Memorandum

Date: January 5, 2018

Re: **January 9th 2018 Planning Board Workshop**
Level III Site Plan
126 room extended-stay hotel/parking development, 203 Fore Street (#2017-245)
Chatham Portland DT LLC, Richard Mielbye, Applicant

Drawing file: Prelim / P11_Landscape Plan.pdf

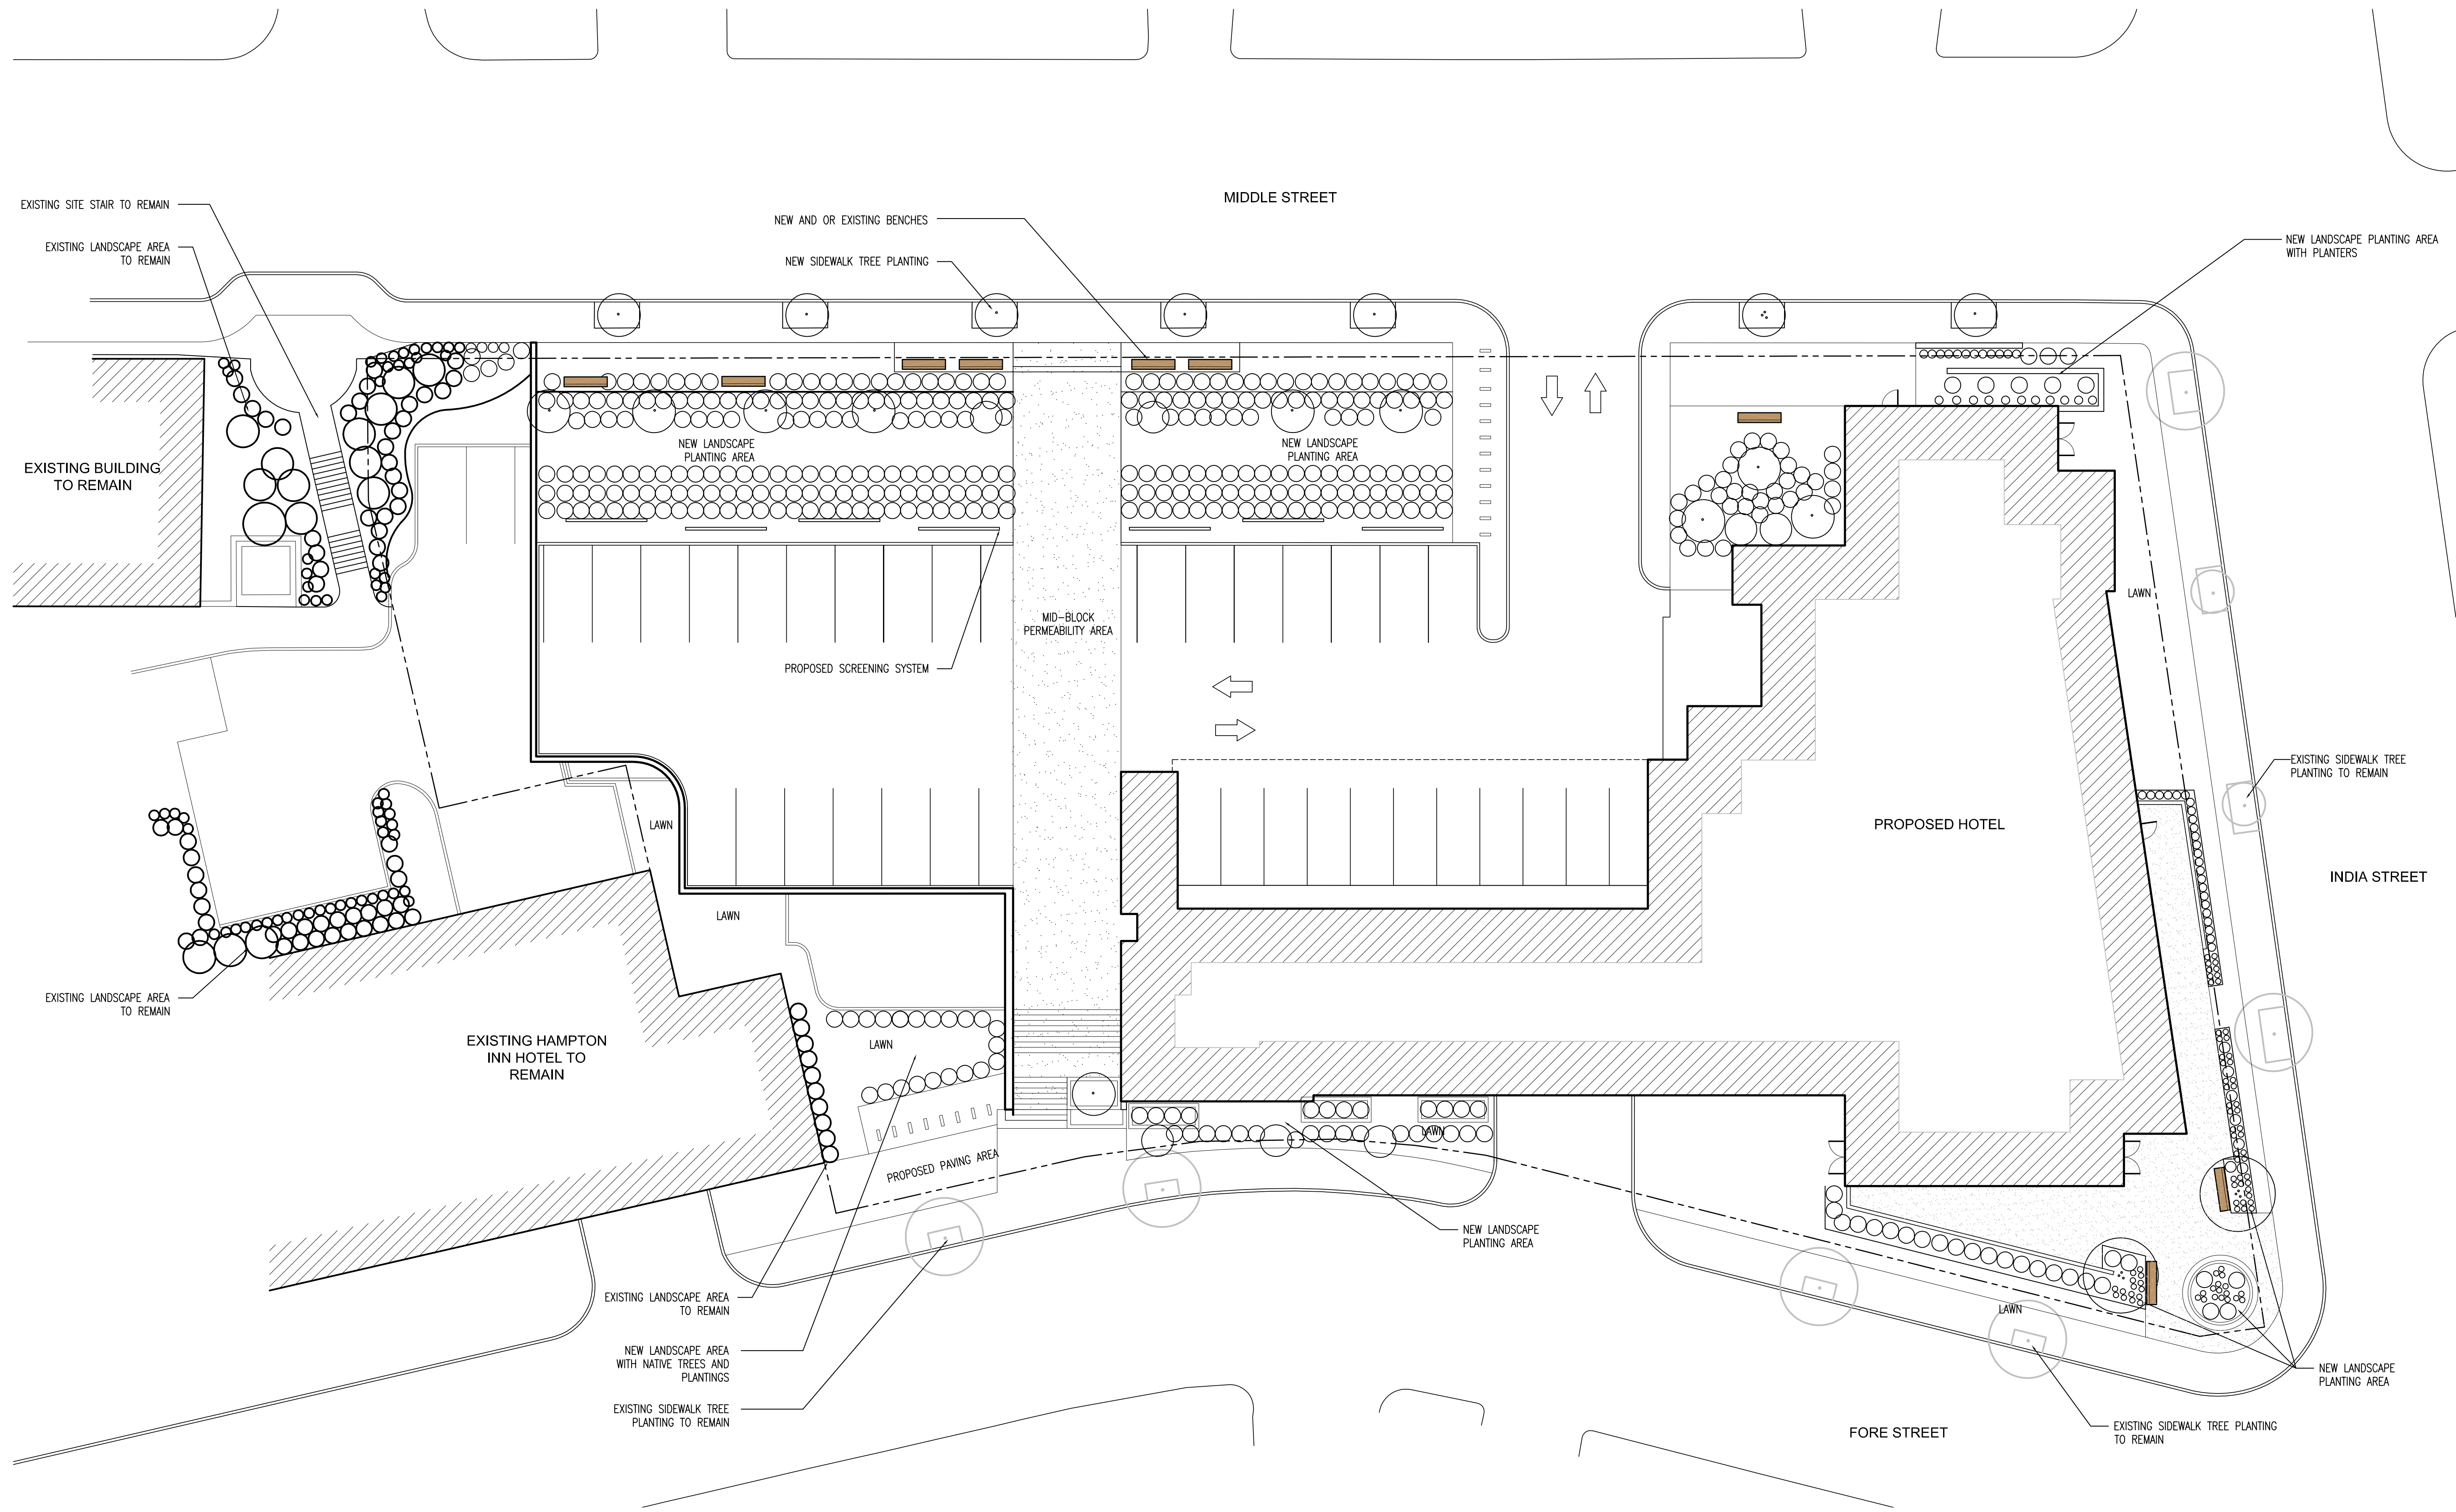
Landscape Preservation / Site Landscaping and Screening – There are no significant landscape or natural features to preserve. The applicant will need to screen surface parking from Middle and Fore Street.

Landscape Plan - Waiting for final submission. Staff will provide guidance on the landscape locations and detailing (Plan P11).

Drawing file: Prelim / P3_Existing Conditions Plat.pdf

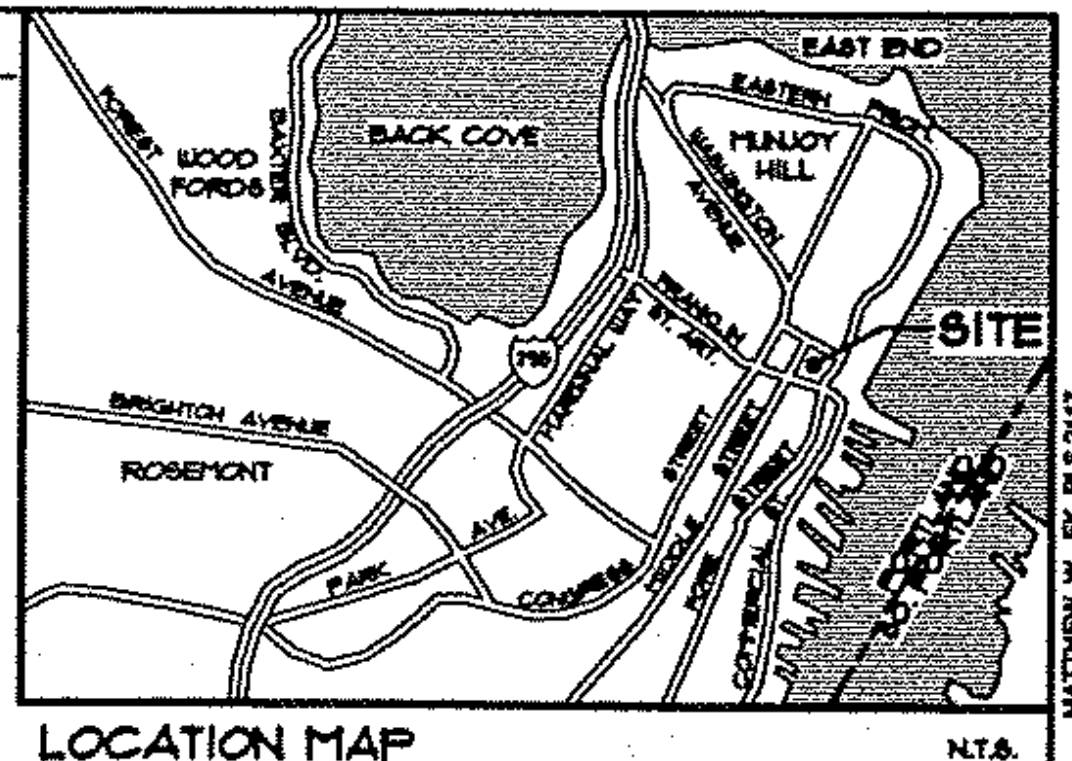
The Boundary Survey needs to be updated to reflect current conditions and show the property line between the two parcels.

Drawing file: Prelim / P4_Existing Grading and Utility.pdf

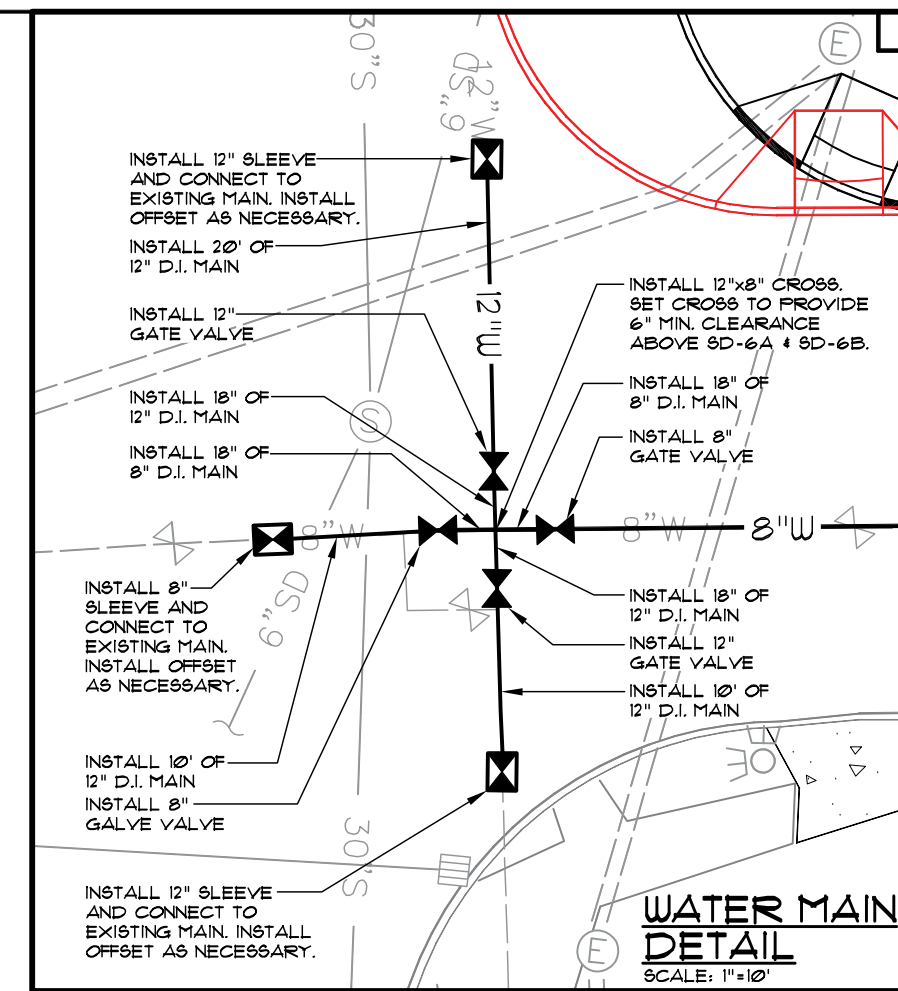
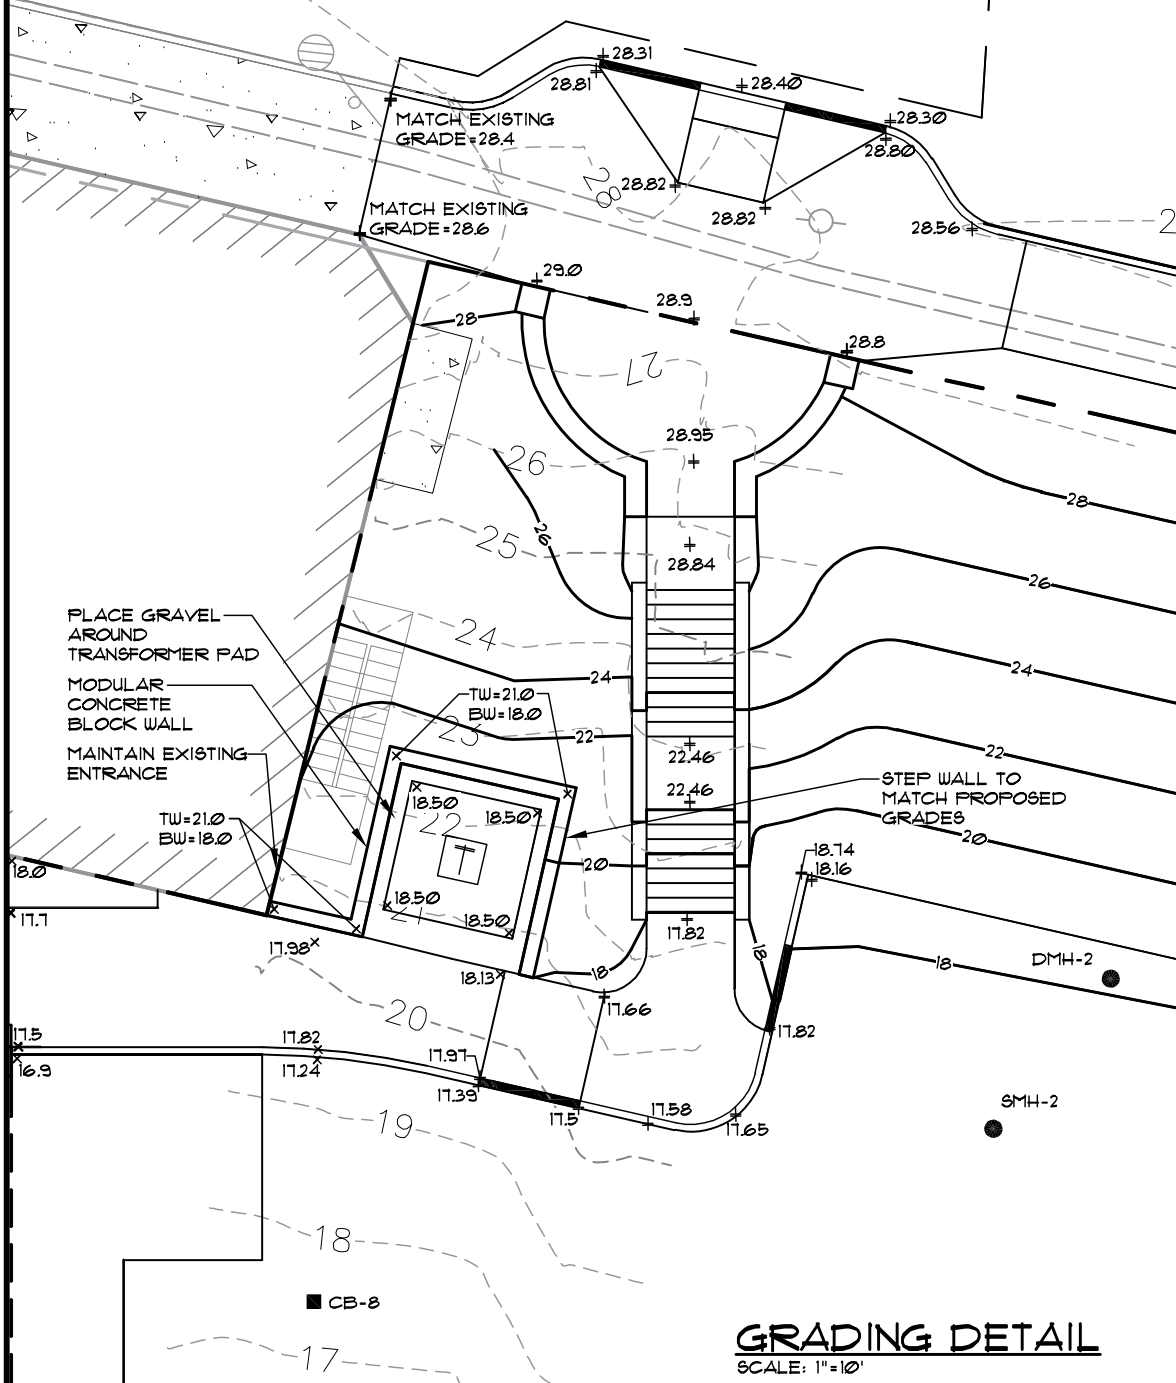
- *We have concerns with the proposed parking deck being located over the existing utility easement. In addition to maintenance clearance concerns, the deck corner support would be very close to the existing SD-2 stormdrain. Provide additional information on clearance, deck support footprint and/or stormdrain relocation.*
